**RE: Homestead at Sterling Ranch Filing No.2 and Branding Iron at Sterling Ranch Filing No. 2 - Early Grading & Utility Plan Submittal
Response to Comment Letter.**

Grading and Erosion Control Plan / SWMP

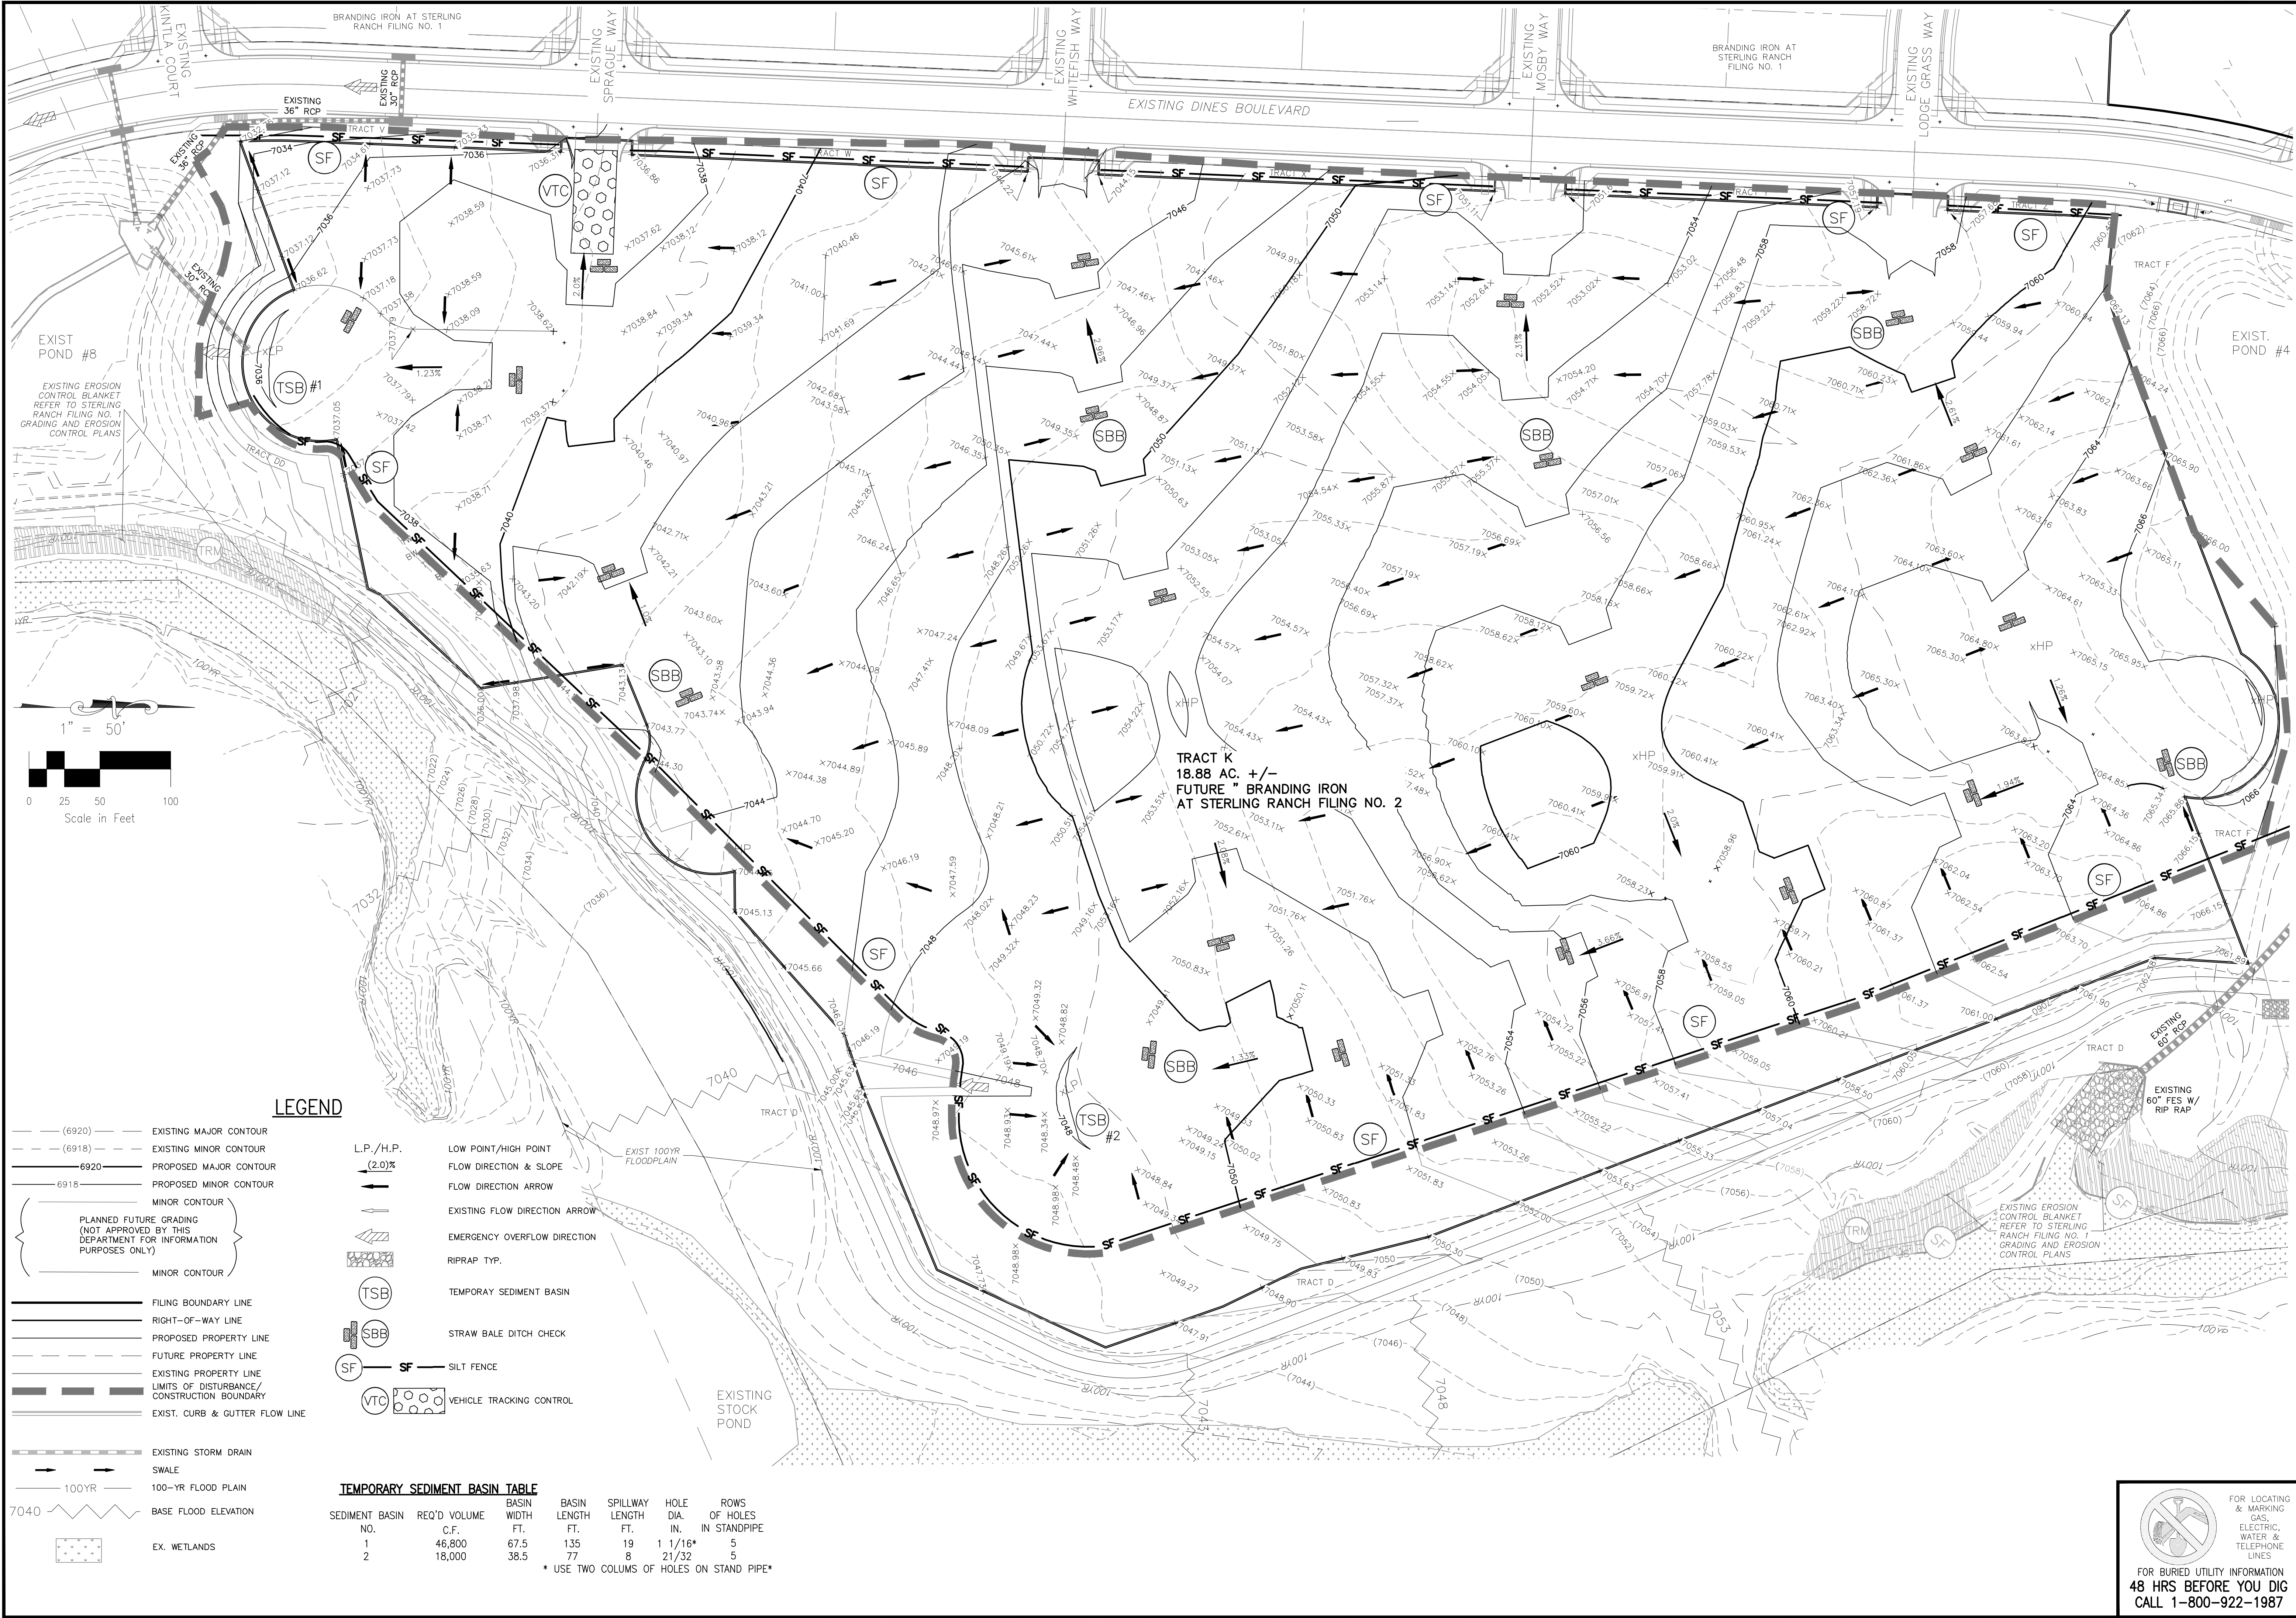
1. Revise notes to the current version, see attachment. **The construction notes have been updated on both cover sheets.**
2. Revise the plan to not show any work near the Sand Creek channel. (The channel improvements and wetland mitigation plan work has not been submitted and approved through previous applications). **The "proposed" grading has been pulled back approximately 50' feet from the top of the Sand Creek Channel. The plans show a bold line for the "Limits of Disturbance".**

3. Show the limits of disturbance line on the plan and call out a safety fence or silt fence for this line that is 50 foot back from the top of bank of the Sand Creek channel. **Same as above.**
